Our Ref: Y/49/19/HH
Your Ref:

Town & Country Planning Act 1990 (as amended)
Town & Country Planning (Development Management Procedure) (England) Order 2015
Application for Planning Permission for Works or Extension to a Dwelling

Development Demolition of existing garage and replacement with a new build garage
Location Rilbrook House Hoe Lane Flansham

SITE PLAN 1:500

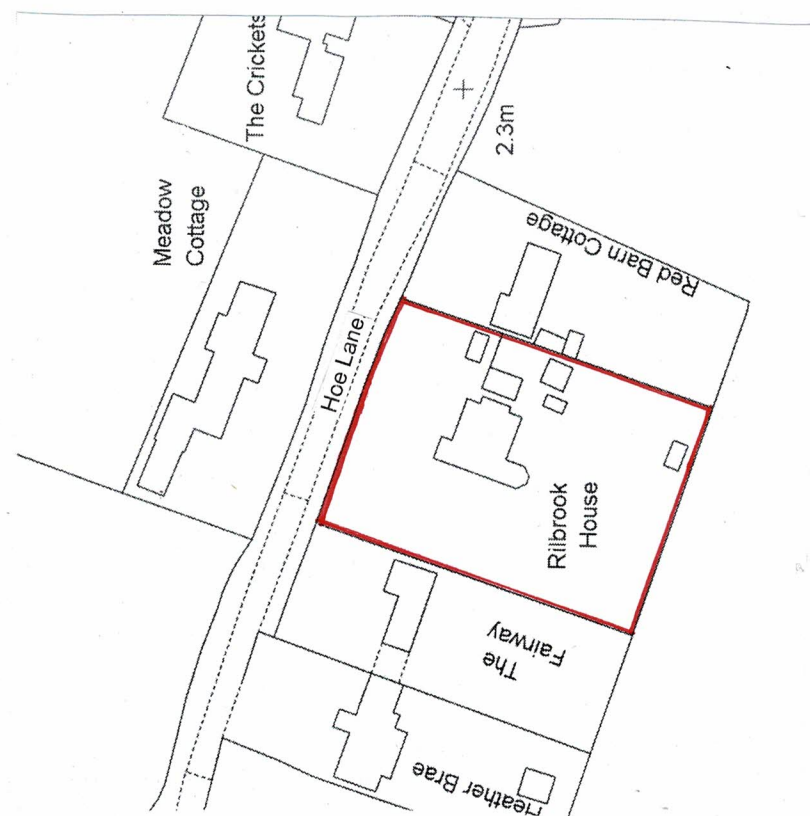
Block Plan

Please include dimensions to the other side and front boundary.
